MEMORANDUM

SUBJECT: Abert Ranch Subdivision
P-17-005 and SP-17-007
Response to Comments Memorandum
LSC #164890

Following are the LSC Transportation Consultants, Inc. responses to the August 4, 2017 El Paso County Development Services Department comments regarding the March 20, 2017 Transportation Memorandum by LSC.

Figure 2  
**Abert Ranch**  
**Site Plan**  
 Abert Ranch (LSC #164890)

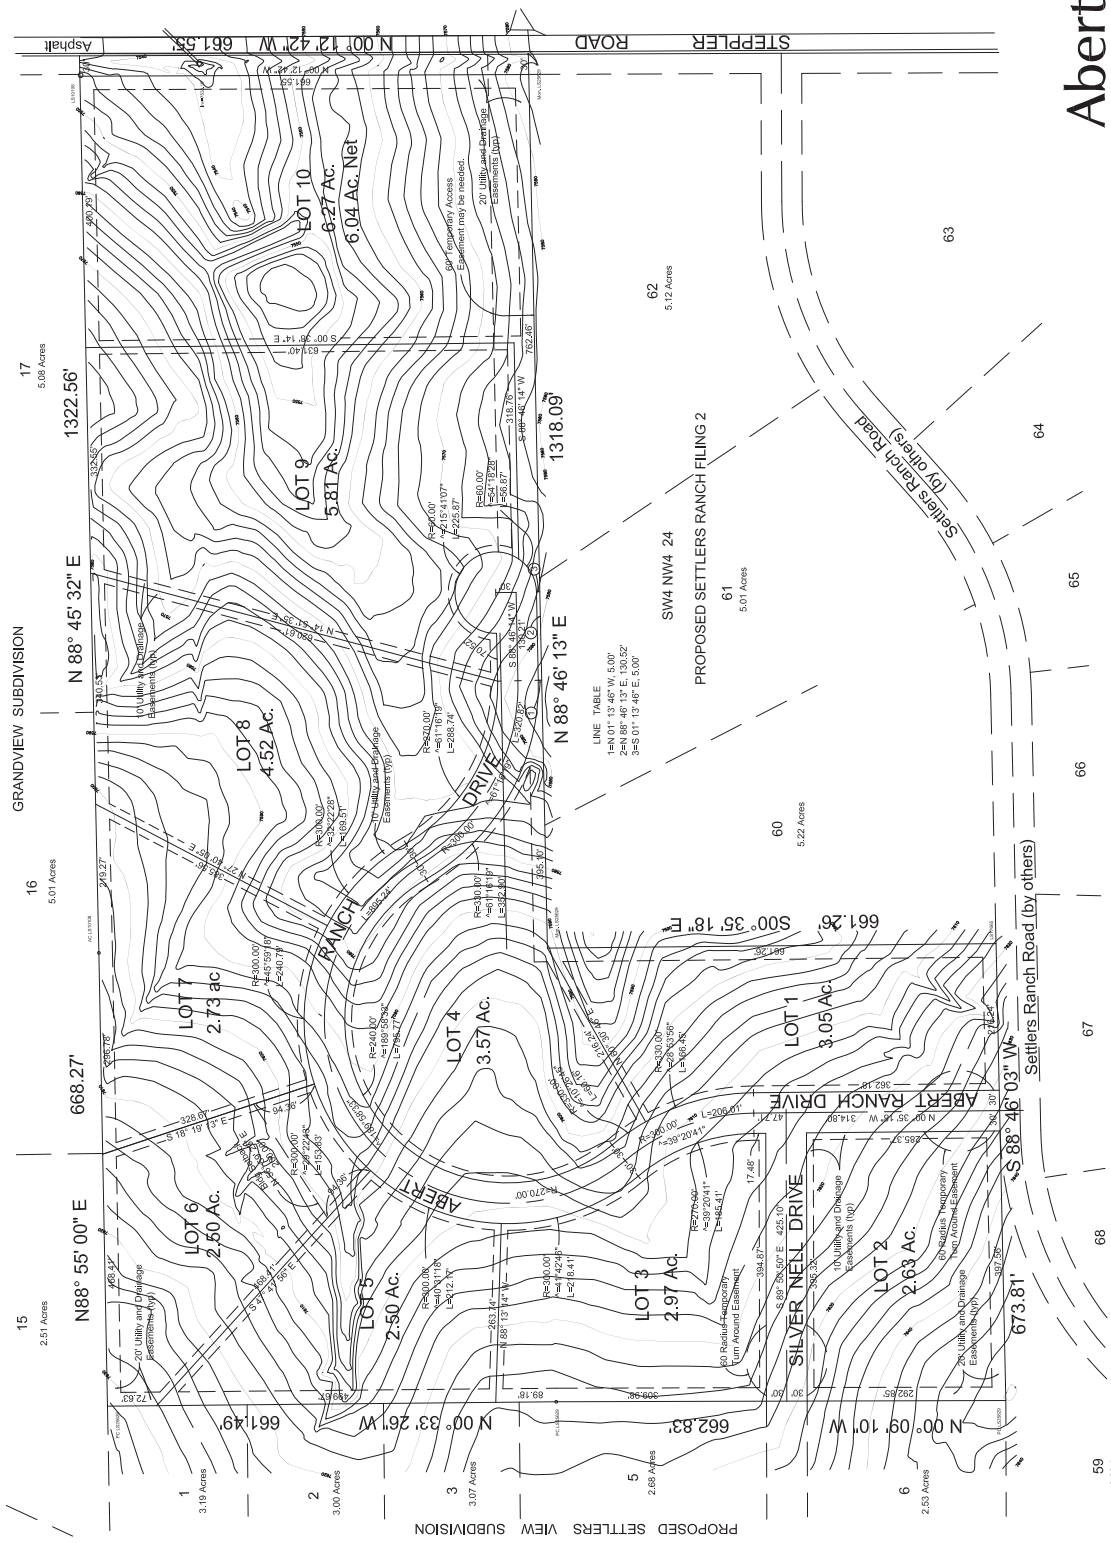
Page 1: Per ECM Table 2-5, minimum centerline radius is 300 ft. Revise or submit a deviation request.

LSC Response: A deviation request is included with this resubmittal.

Proposed Nature and Extent of Deviation: The applicant is requesting a deviation to allow a 270-foot centerline curve radius for the proposed Abert Ranch Drive north of Silver Nell Drive (proposed). Please refer to attached exhibit.

Comparison of Proposed Deviation to ECM Standard: Proposed centerline radius is 270 feet. The standard is 300 feet (minimum).
